Subject: RE: Planning Consultation on Y/21/19/DOC

Engineers Comments Regarding Condition 9- surface water drainage design

Site Address: Land East of North End Road Yapton BN18 0AG

Approval of details reserved by condition imposed under ref Y/49/18/PL relating to Condition No.6 Construction & Environment Management, No.7 contamination, No.9 surface water drainage, No.10 maintenance & management of surface water drainage, No.12 materials & finishes and No.16 surface water onto public highway.

Typical 575mm (max) high retaining wall section 1:20
(see site plan for locations)

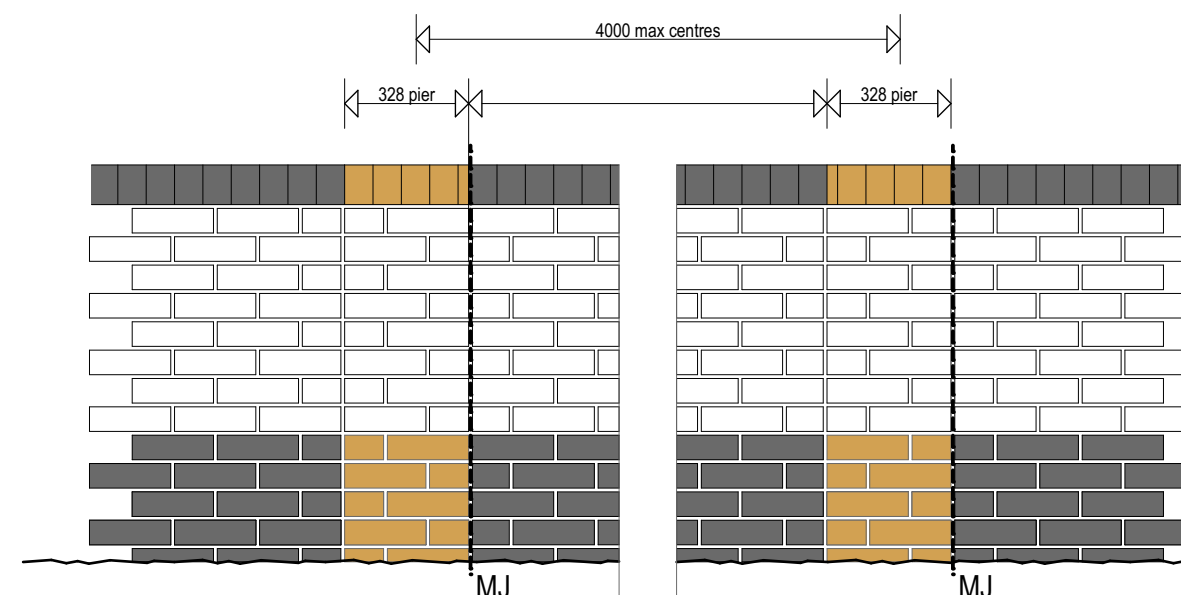
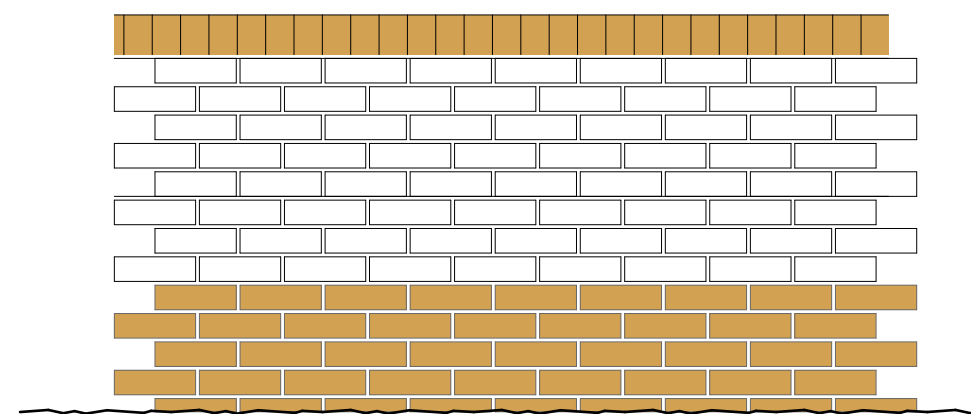
Please provide details of the proposed retaining walls, and in particular the drainage associated with these.

- Please find attached a detail of the proposed retaining wall applicable for the retained height. Regarding the drainage associated with the proposed wall I believe that the construction of the weep holes shown on the detail will adequately cater for any surface water flows that you may have concerns about.
- The SuDS Maintenance Manual has been amended in line with your comments.
